WS

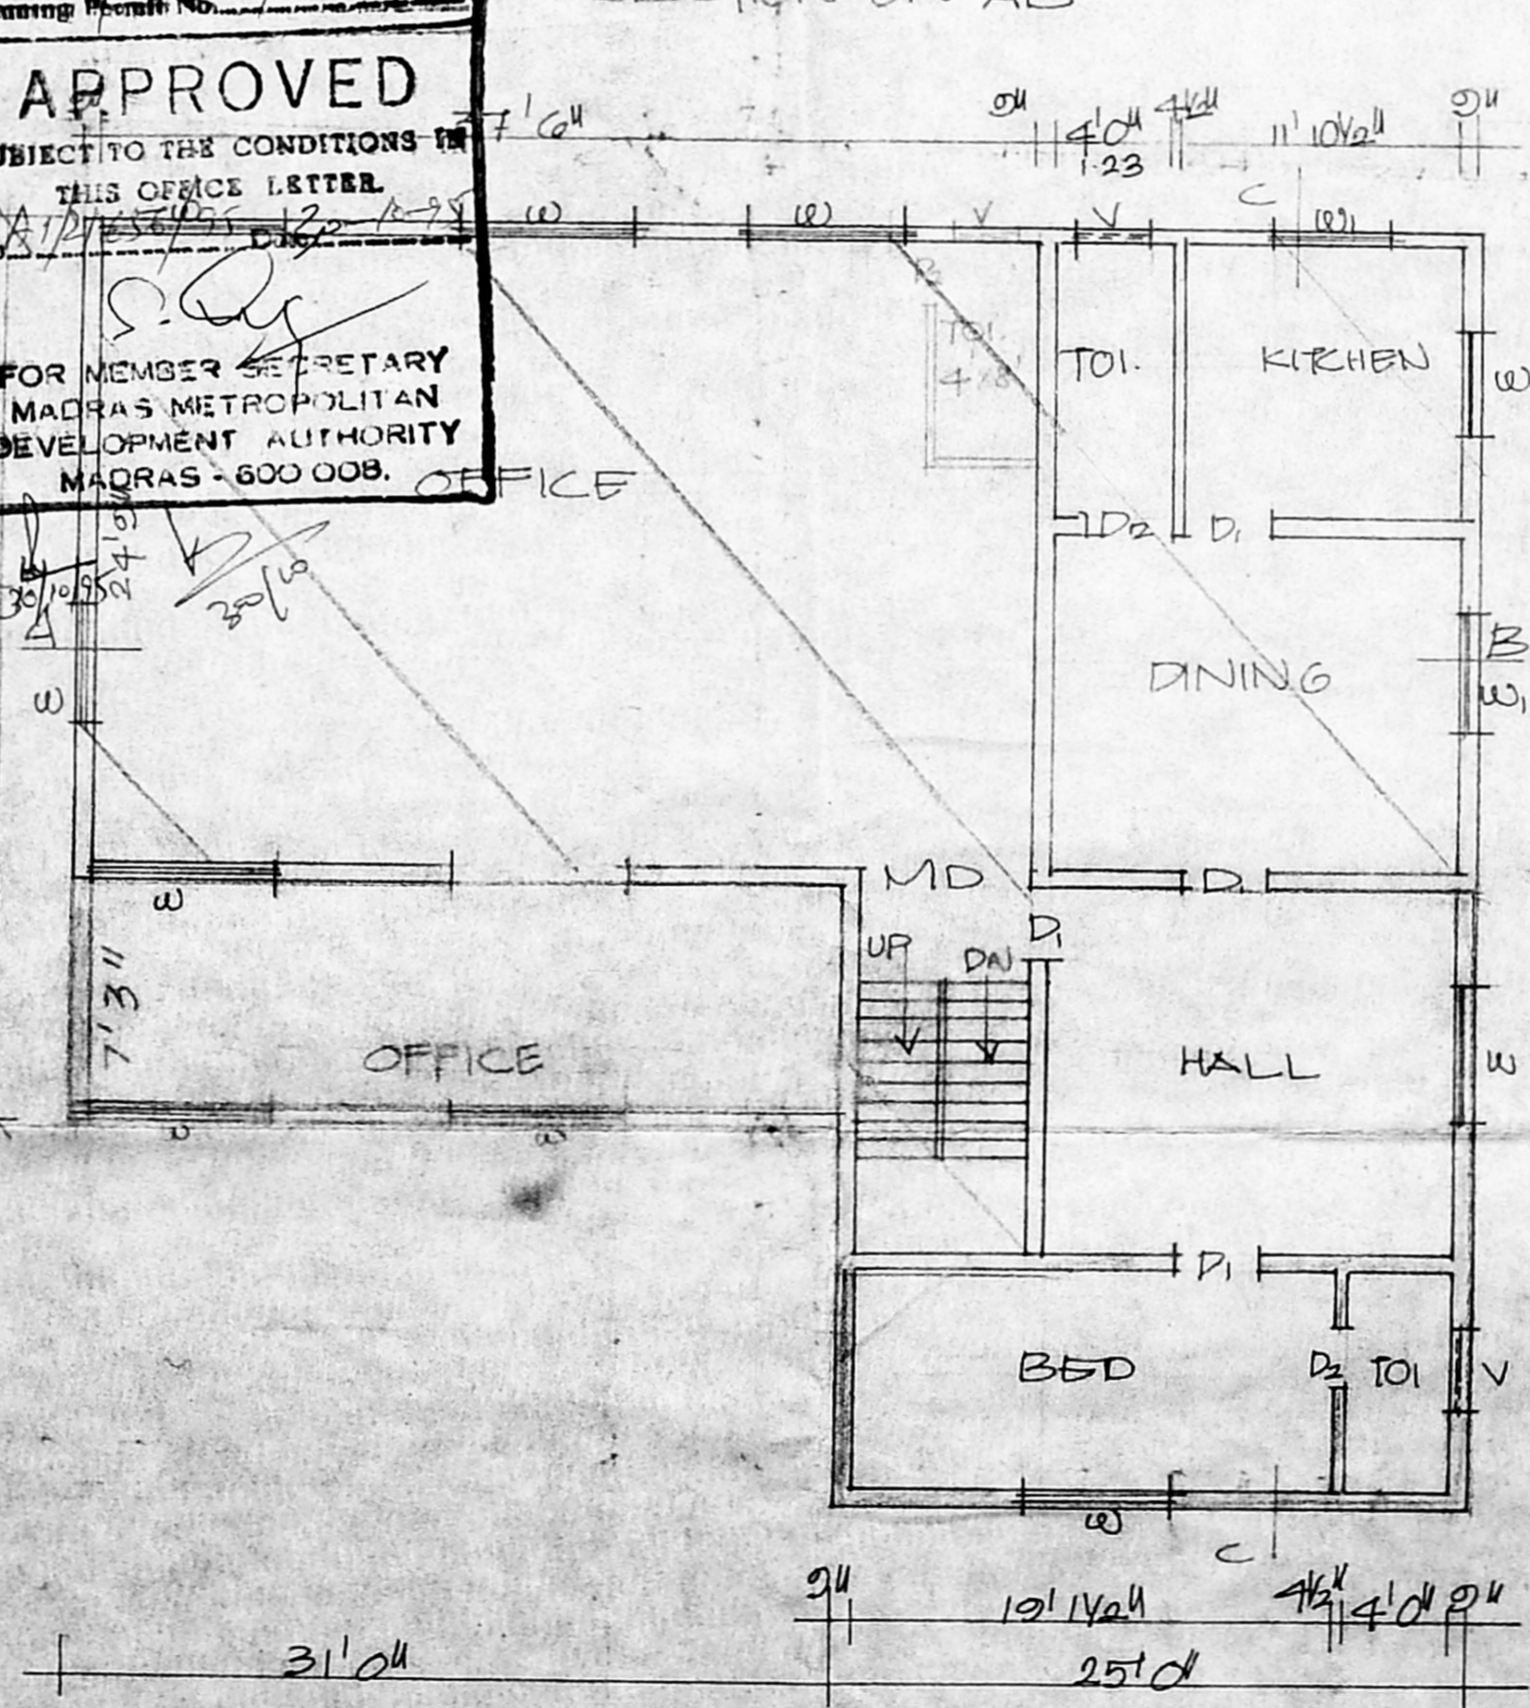
- a) Rain water conservation regulations
- b) Rain water conservation regulations notified by MMDA, should be adhered to strictly.
- c) Five copies of revised plan ~~at~~ mentioning as ~~Dear Sir~~, regularisation & proposed addition and ~~Dear Sir~~ in a file of a plan.
